**RFI**

**RFI #:** 193  
**Date:** 9/25/2012  
**Job:** EB-02 Keller Springs Lofts  
**Phone:** 877-777-5115

**Subject:** Exterior 2HR wall

**Drawing:** 1/ 5.5, 1/ 5.5A, 2/ 5.5A  
**Cost Impact:** None

5.5A
STAIR SECTIONS

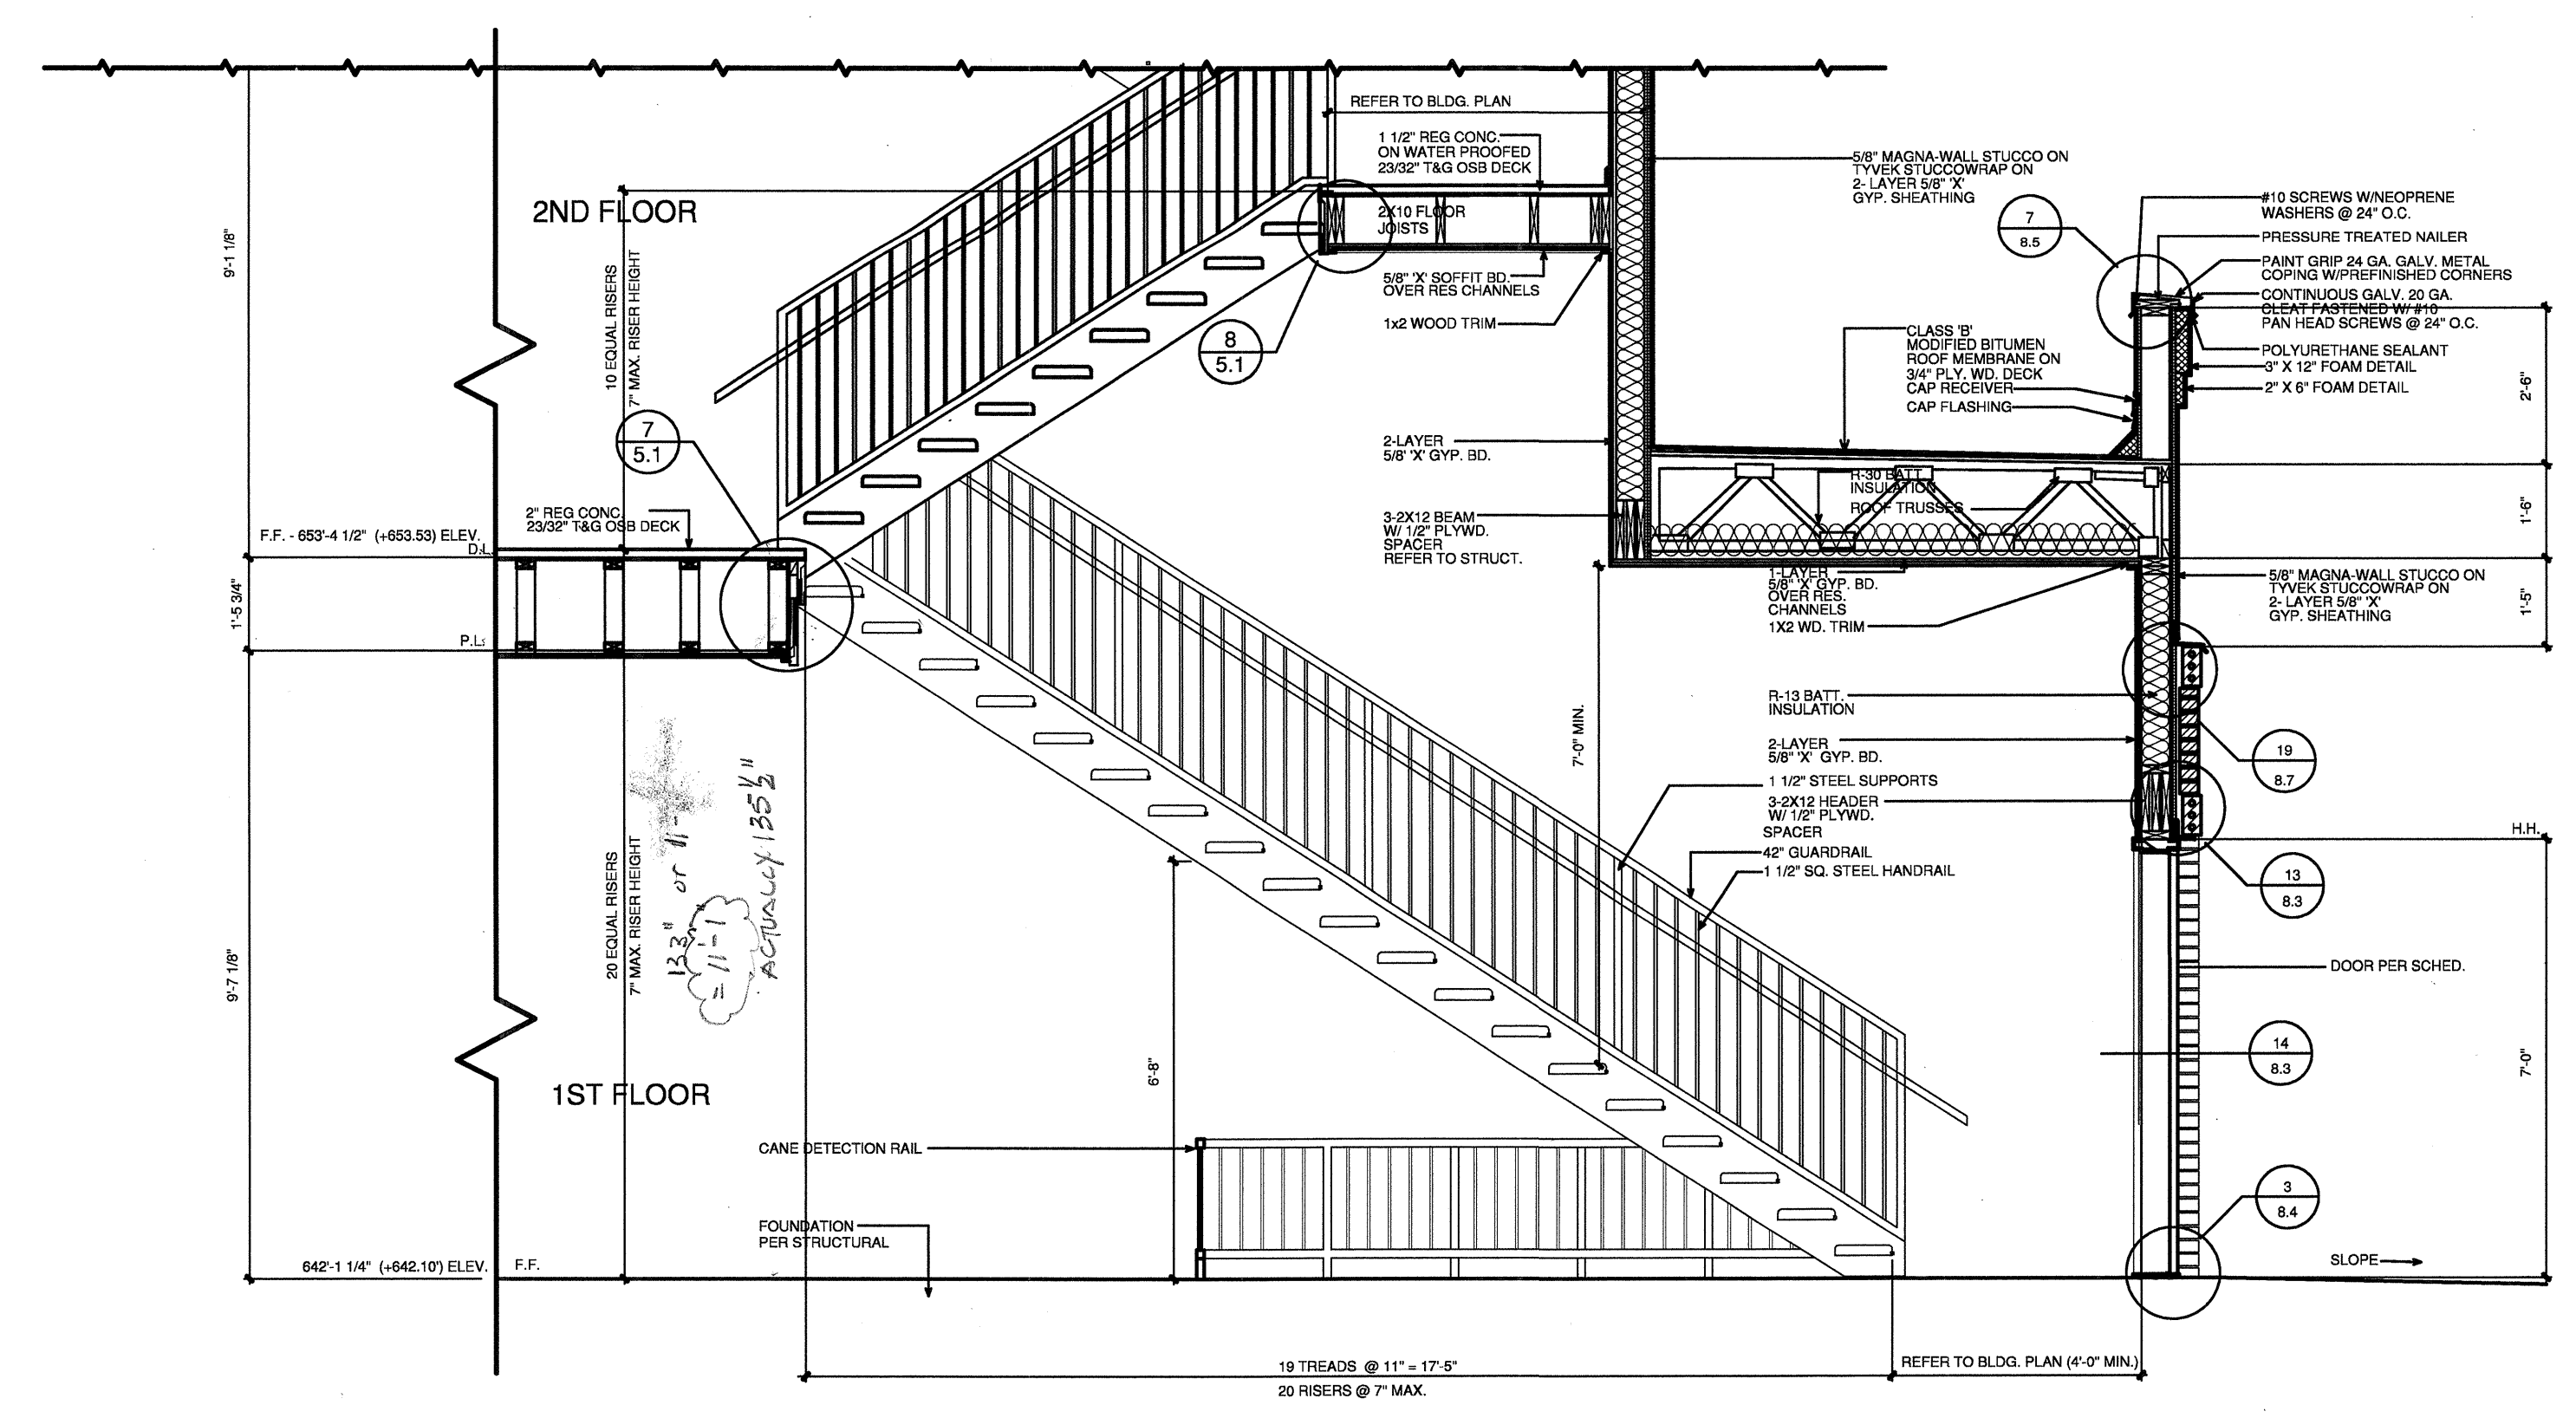
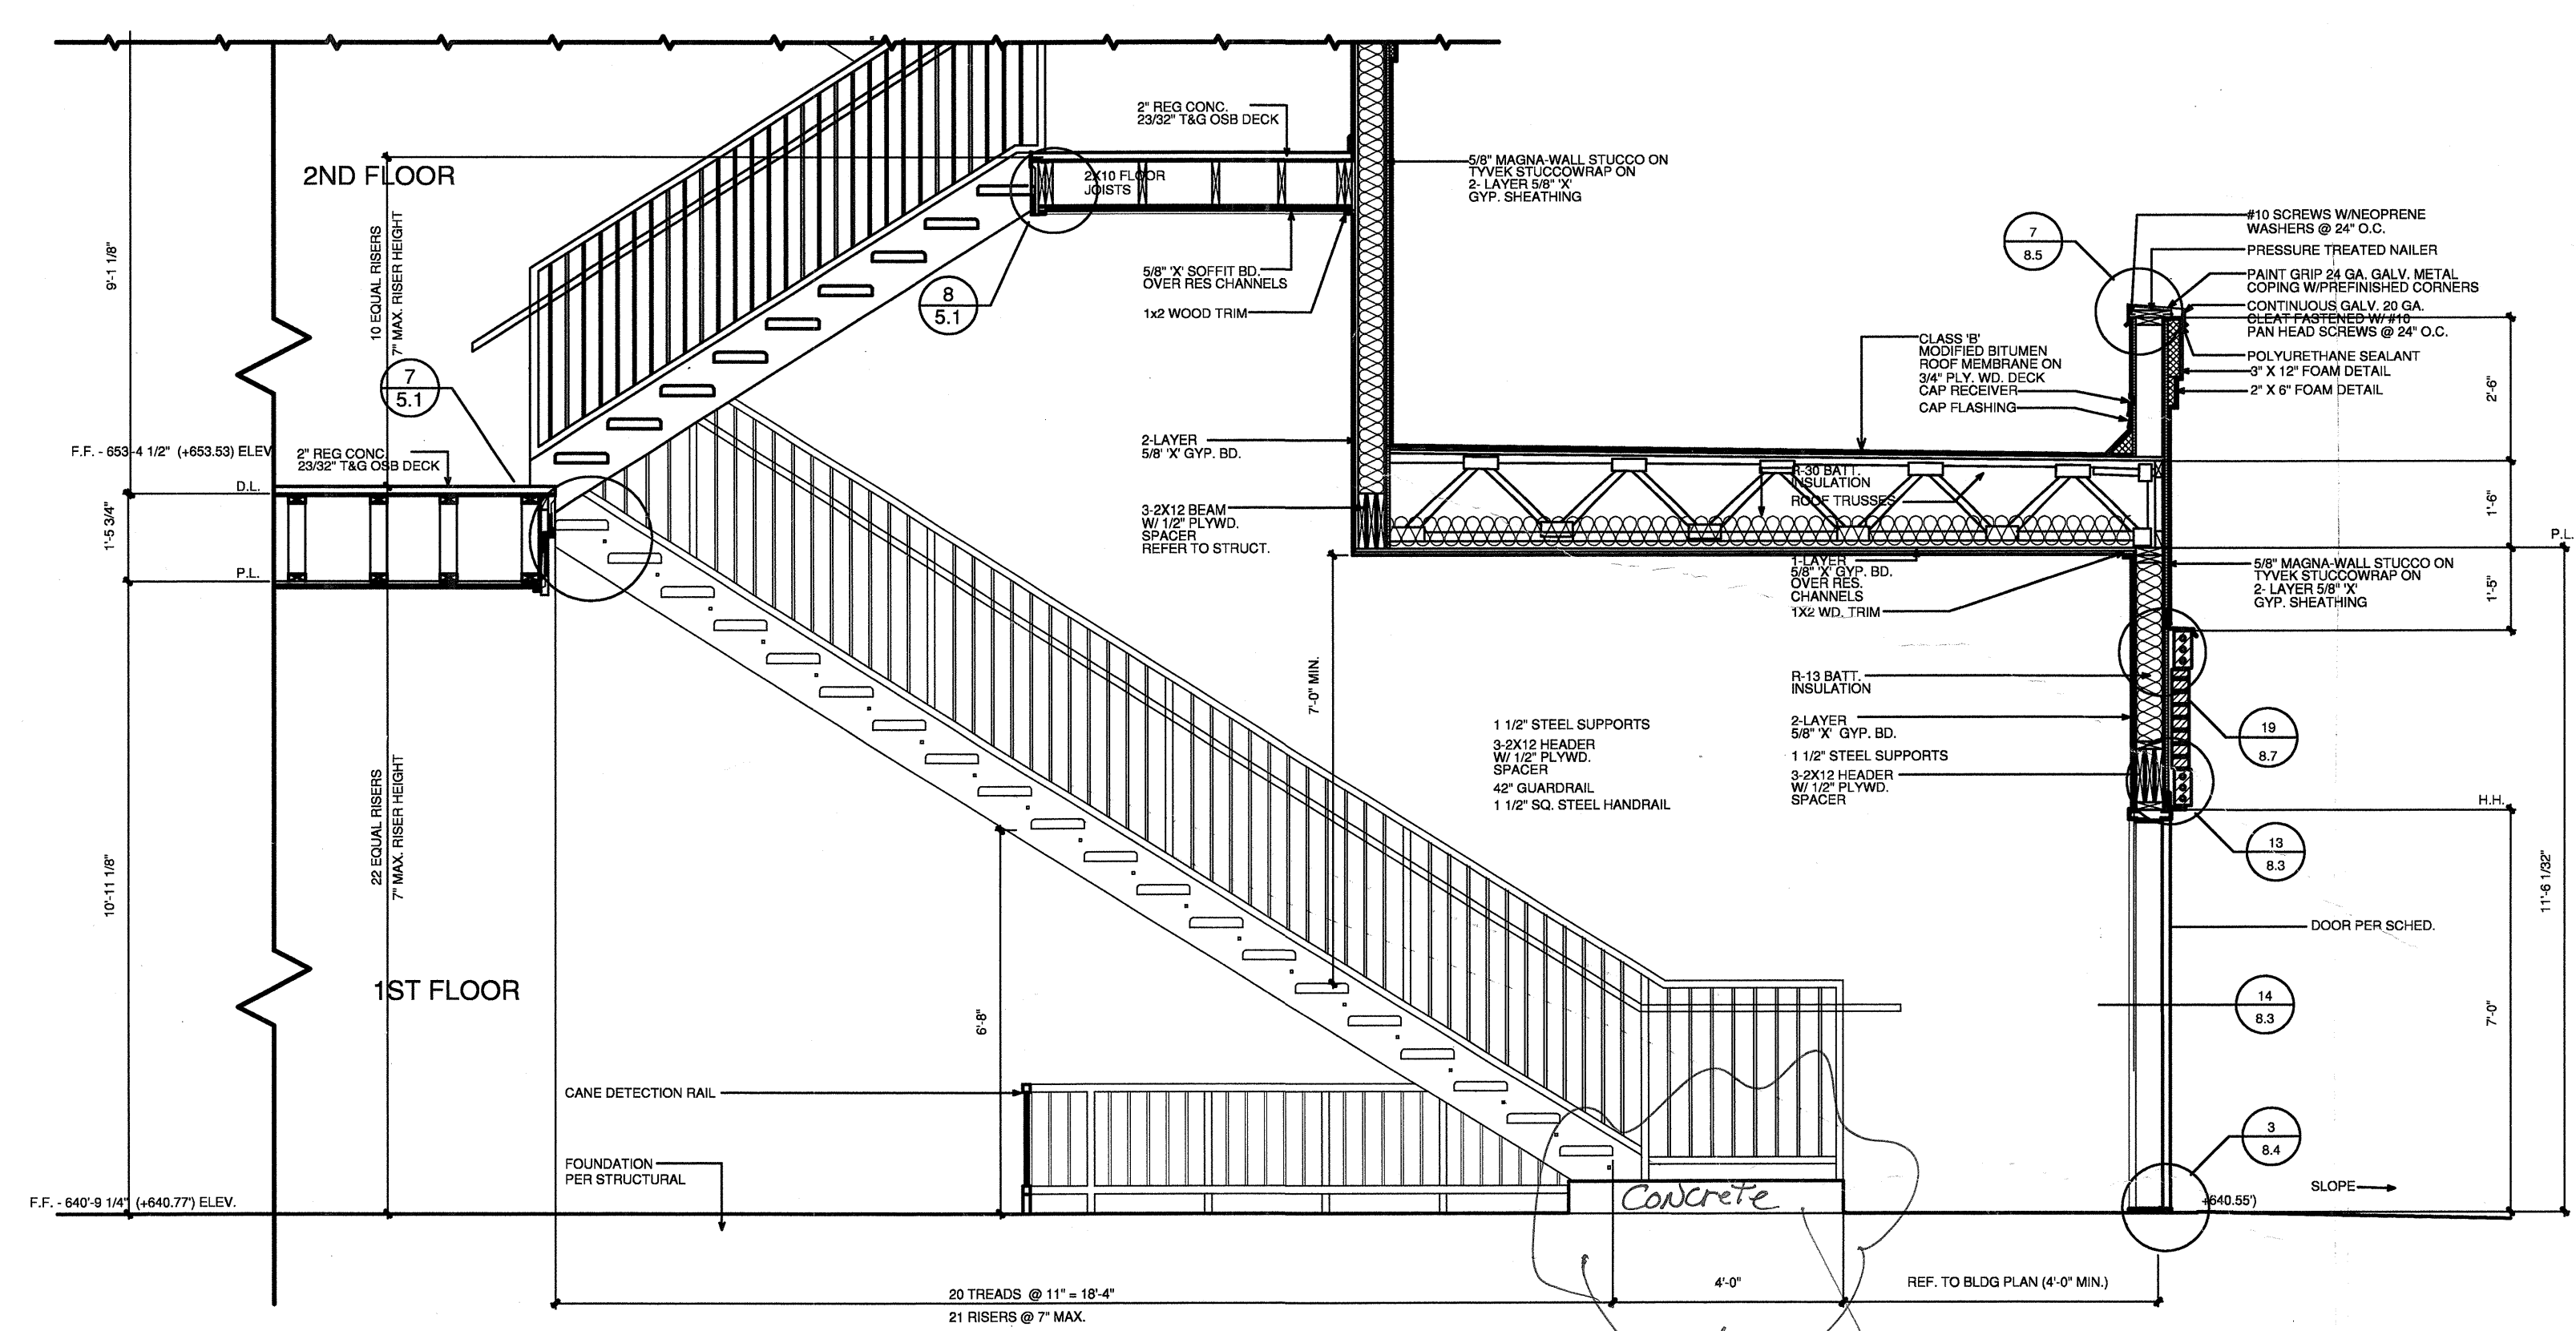
**Request:** See the attached framer's RFI on the 2HR stairwells with low roofs. Please provide the requested information and detail. I would like to add a question about the exterior wall. Isn't it correct that the actual exterior wall of the stairwell only has to be 1 hour?  
**Date Required:** 9/28/2012

**Response:**  
PPO response: PPO recommends installing a ledger board as illustrated in detail 15/S4.02 for attachment of the truss hangers.  
BGO response: All 4 walls of the stairs have to be 2hr fire rated per building code.
